PROJECT ARCHIMEDES

WENONA SCHOOL

ACCESSIBILITY REPORT

18 June 2015

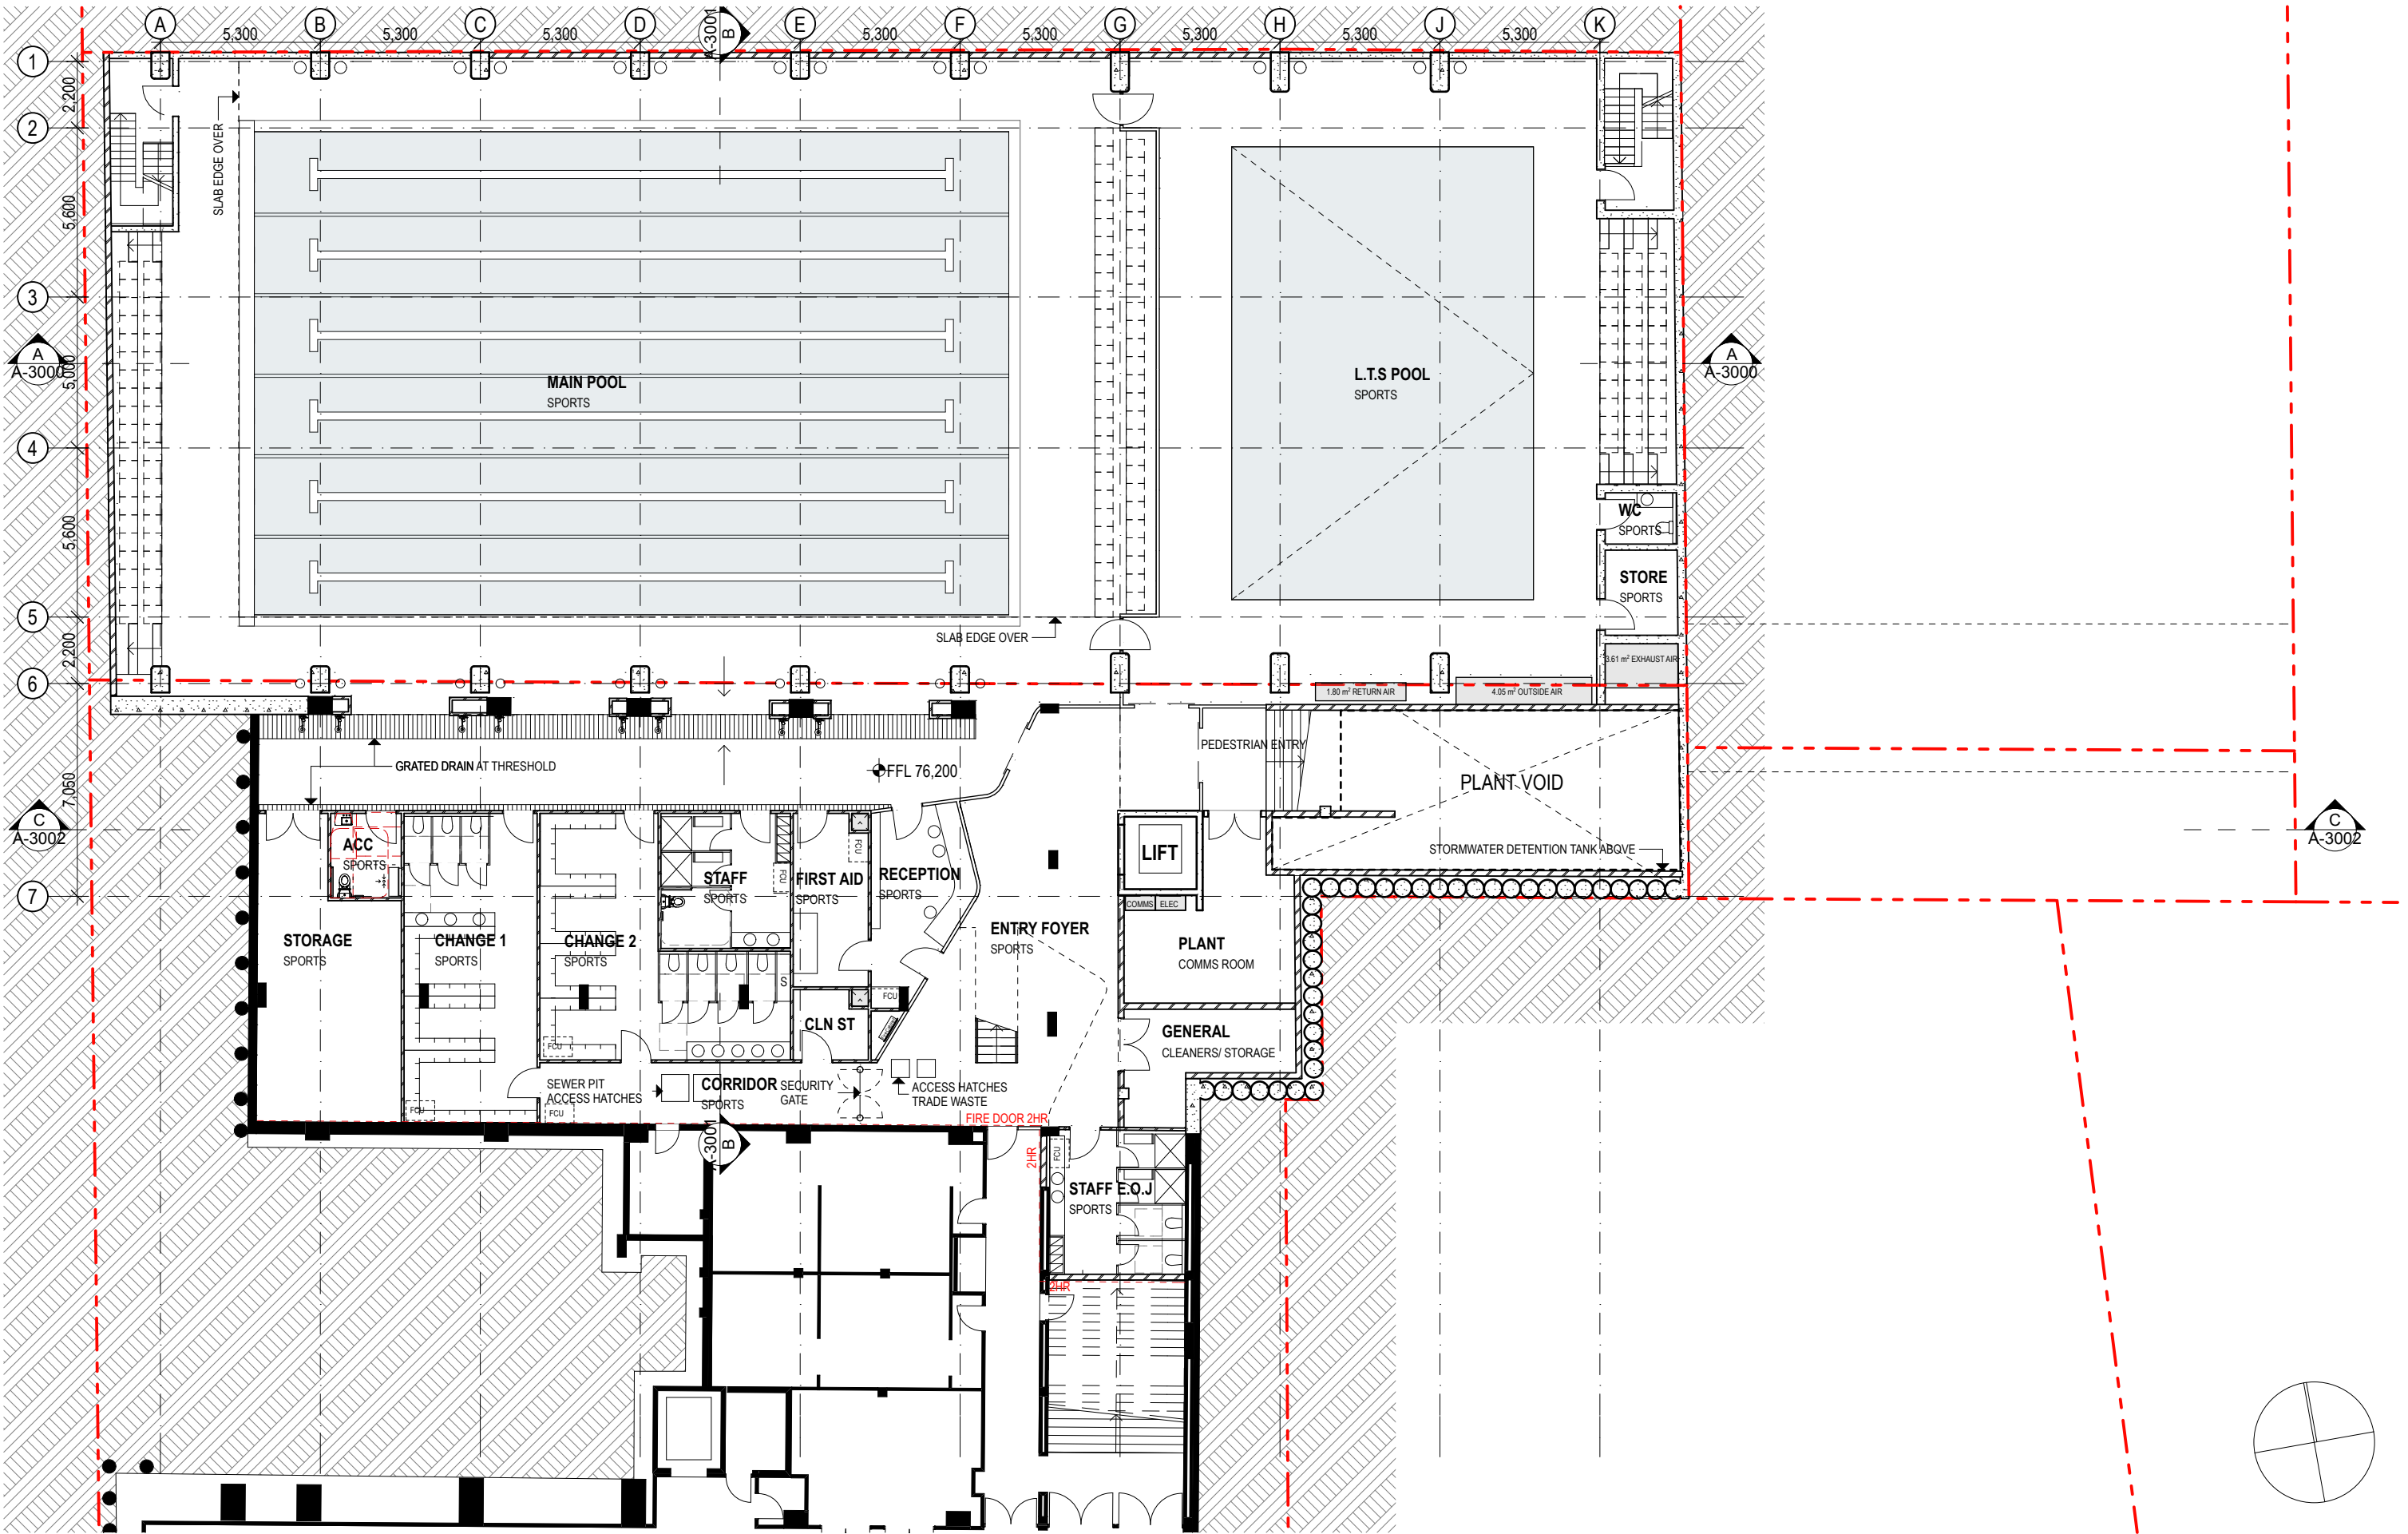
The existing entrance to the gymnasium being retained is located on lower ground level 2. Entry is via 3 sets of double-hinged doors that are shown to be 850mm min. clear width opening each leaf with suitable circulation on both sides, compliant with AS1428.1.

From the entry area, an existing stair connects up to lower ground 2 mezzanine level, where the new sports foyer and existing gymnasium 2 are located. An existing corridor provides a direct path of travel to a new connecting entry door to the new development with suitable width and circulation areas, compliant with AS1428.1 to Pool Entry Foyer.

- (i) Ensure the existing entrance to the gymnasium, being retained on lower ground level 2 and accessible path of travel to new work areas within existing building are compliant with AS1428.1 under the 'Affected Part' requirements of the DDA Premises Standards.

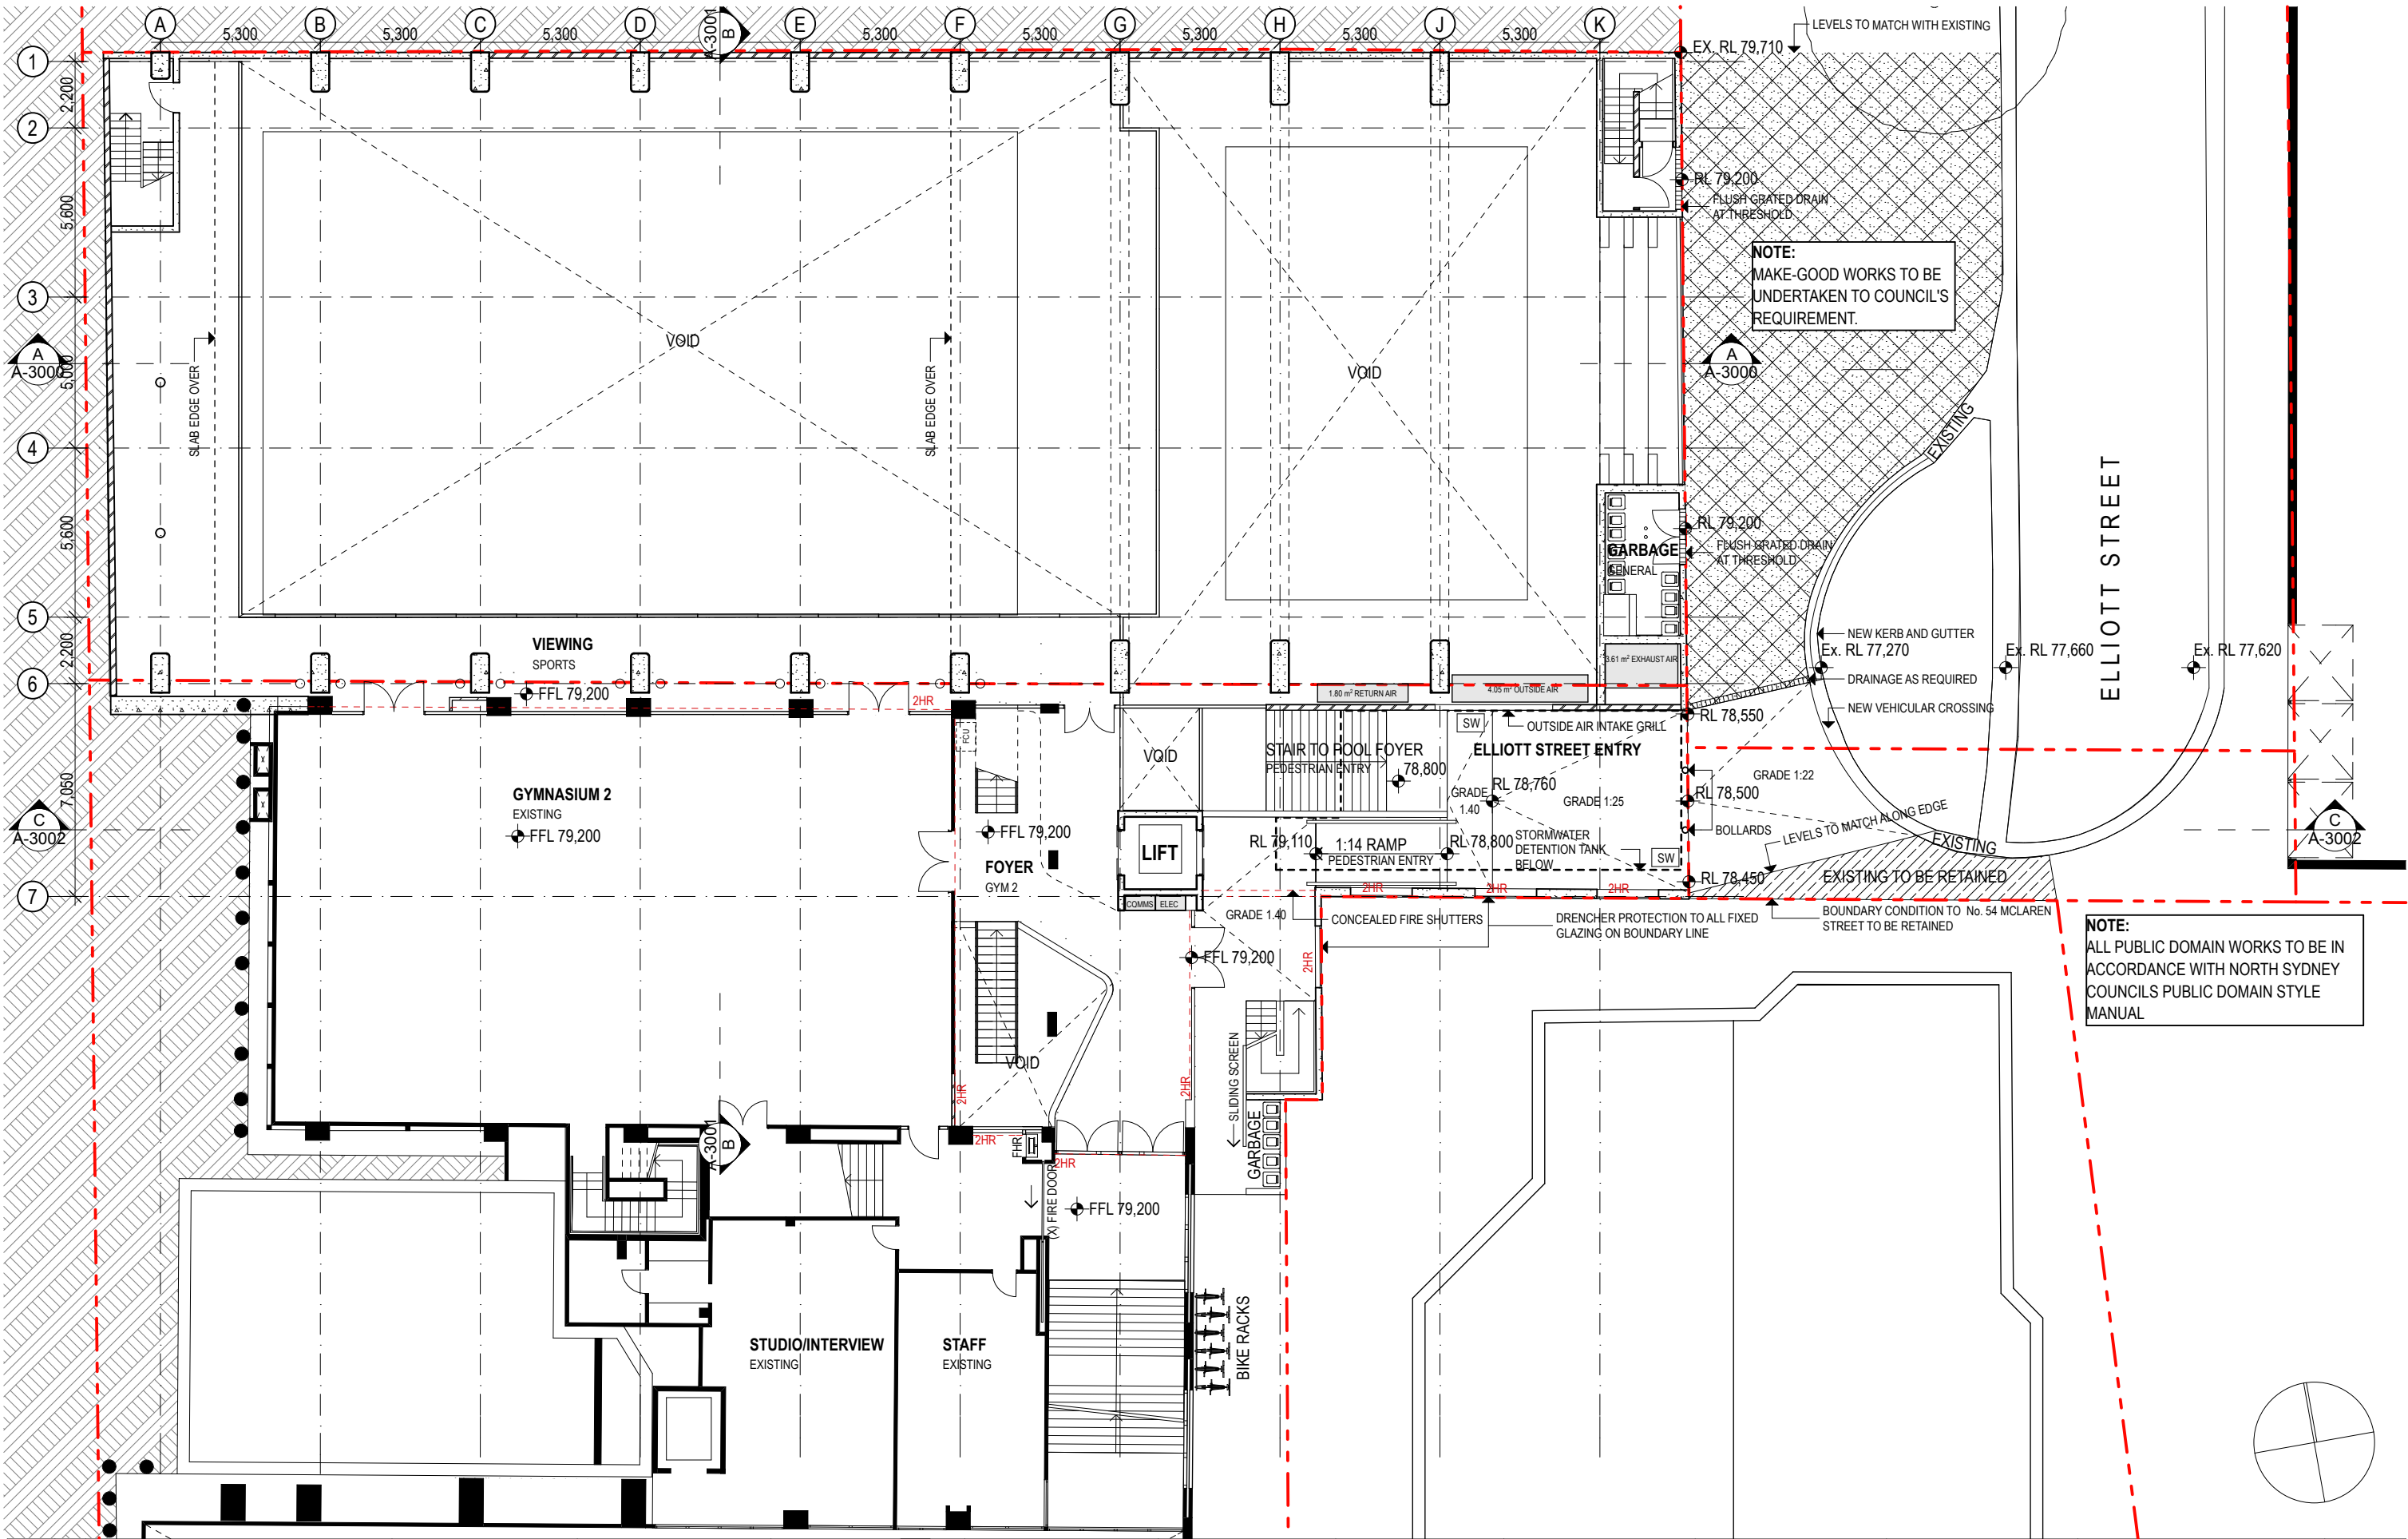
The main entry access to the Recreation part of the STEM development is at lower ground 2 mezzanine level, facing Elliot Street. A doorway is not currently shown but can be easily achieved to provide 850mm min. clear width in compliance with AS1428.1.

The 1:25 walkway is suitable incline walkway for people with disabilities under AS1428.1 to enter the building. Following on is a 1:14 max. gradient ramp with 1200mm min. length level landing areas at top and base areas that leads to lift lobby. The 1:14 entry ramp can be recessed at top and base (or have its side walls extended) to cover the required handrail extensions on both sides of the ramp, compliant with AS1428.1.

The level landing in front of lift and gym 2 foyer doors is at least 1800mm min. length to accommodate 1540mm width x 2070mm length wheelchair turning space to manoeuvre to enter and exit lift and a passing space for two wheelchairs. The level landing at top of stairs down to pool level extends across the full width of stairs and is at least 1000mm min. length to accommodate required handrails and required TGSIs on a level surface.

- (i) Provide handrails on both sides of the Foyer entry stair, compliant with AS1428.1.
